Application for a non-material amendment following a grant of planning permission.

Redevelopment of site to form 60 'Extra Care' frail elderly apartments for the elderly plus ancillary communal facilities, associated car parking and landscaping.

APP/C3810/A/08/2086867 & Minor amendment
LU/61/10NMA

Changes to sizes to 8 no. windows on south elevation.

Scale	1: 200@A1	Date	10.12.2009
Drawn	SMK/NKF	Checked	
Drawing No.	TCL-59-03	Rev.	D

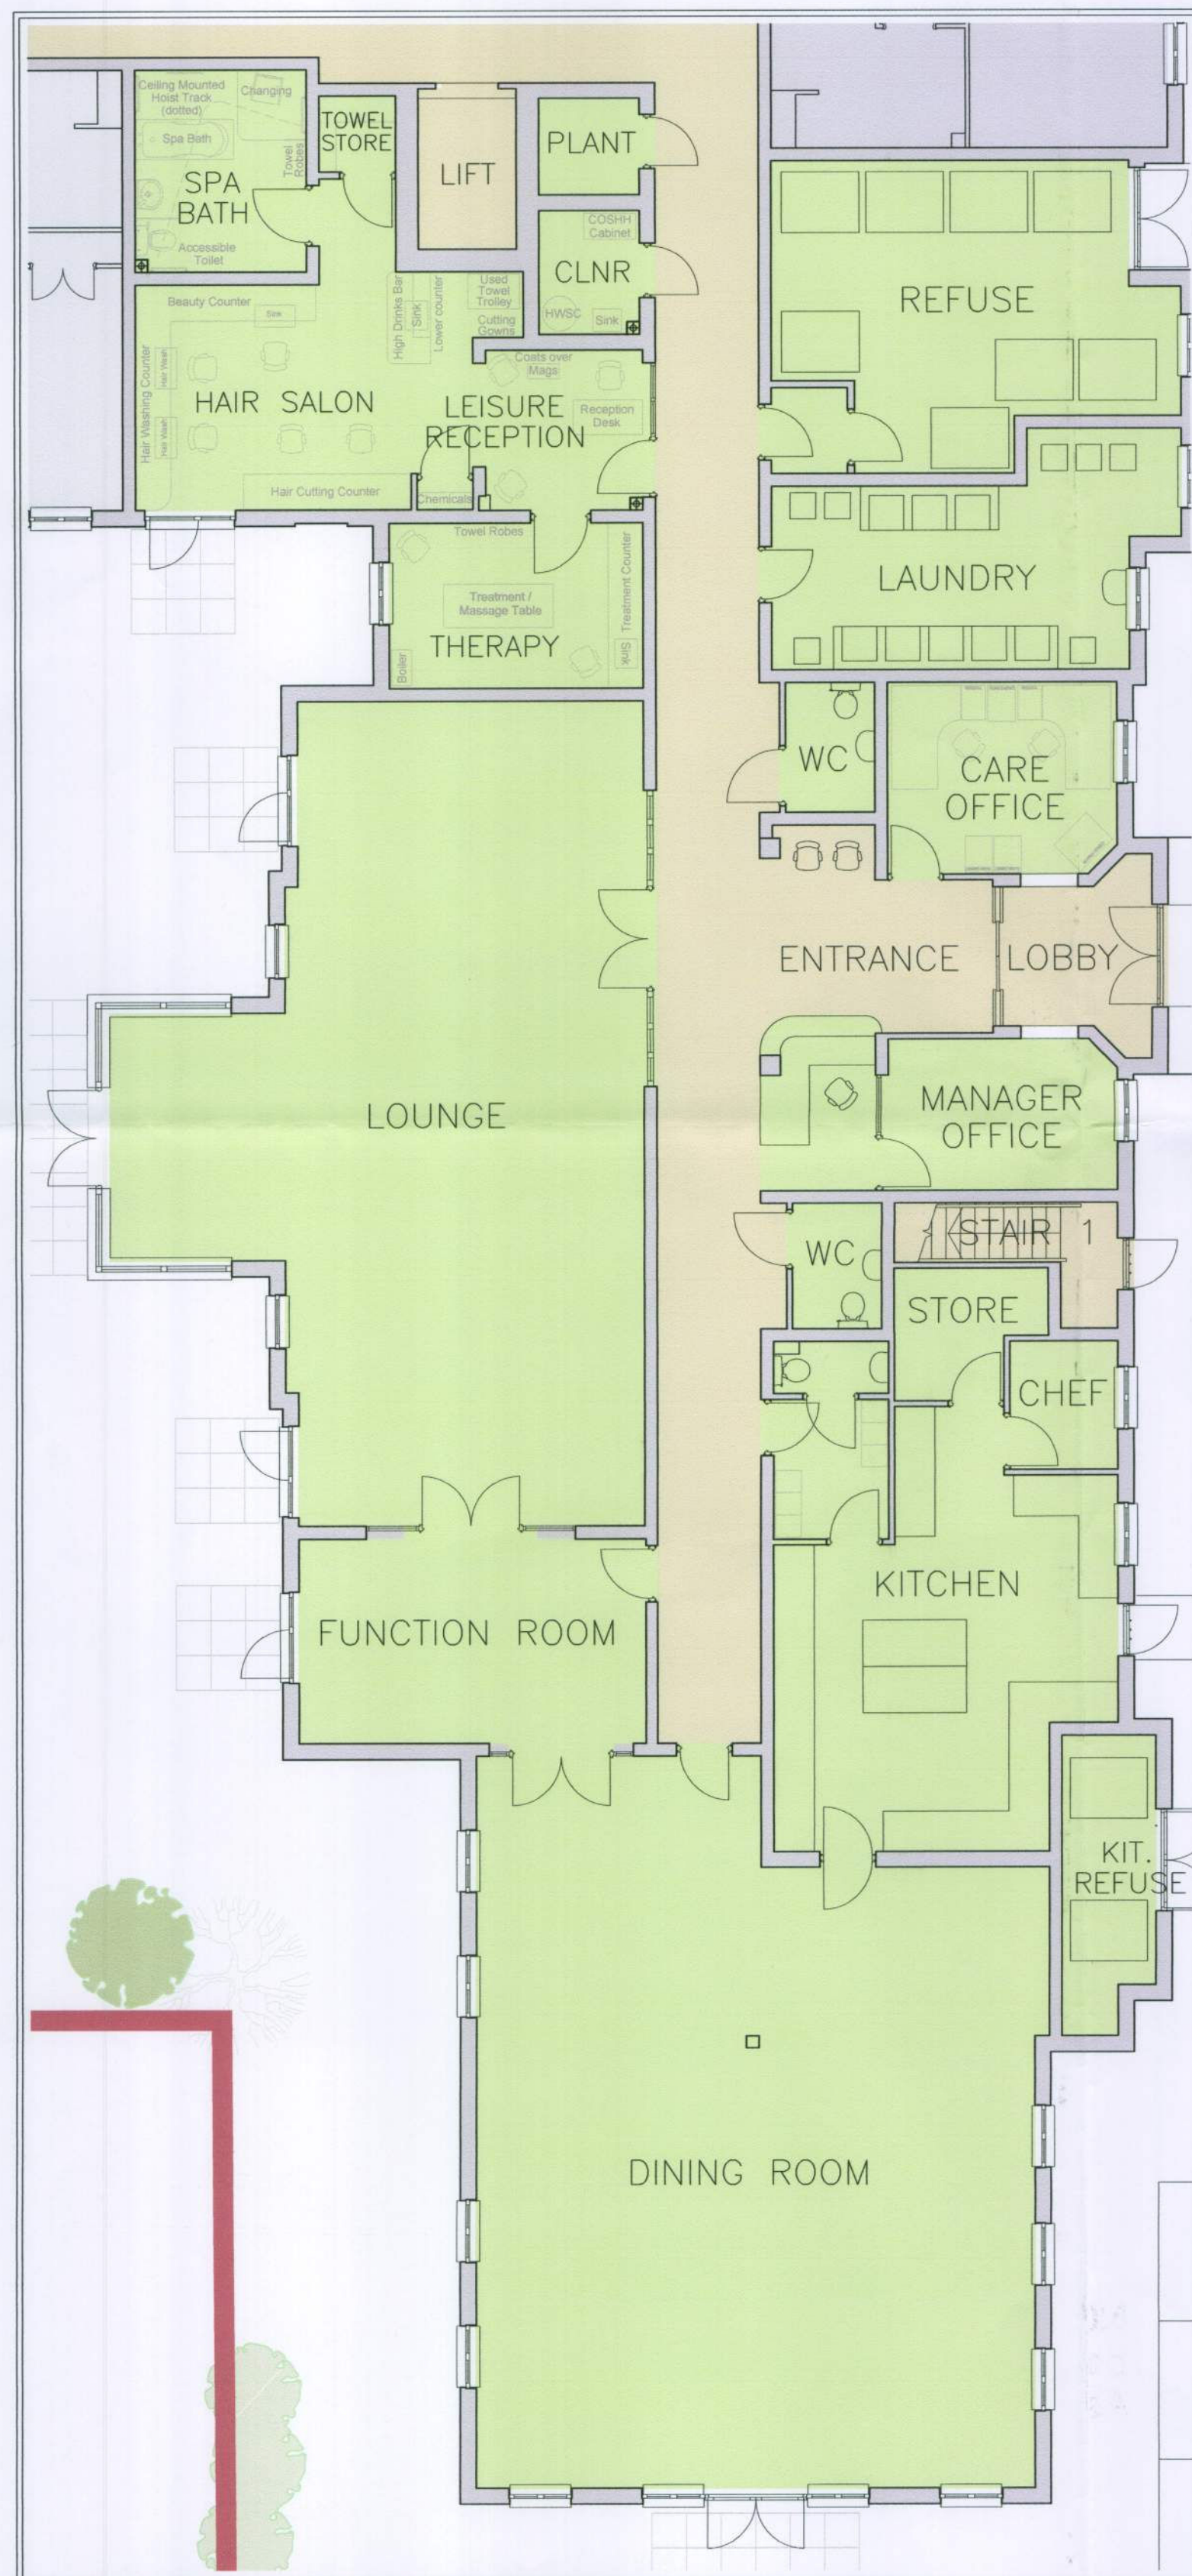
TCL-59-11 Rev C; TCL-59-03 Rev C

To facilitate internal changes to provide 2 no. 2 bed apartments in place of approved 3 no. 1 bed apartments.

TCL-59-11 Rev D; TCL-59-03 Rev D
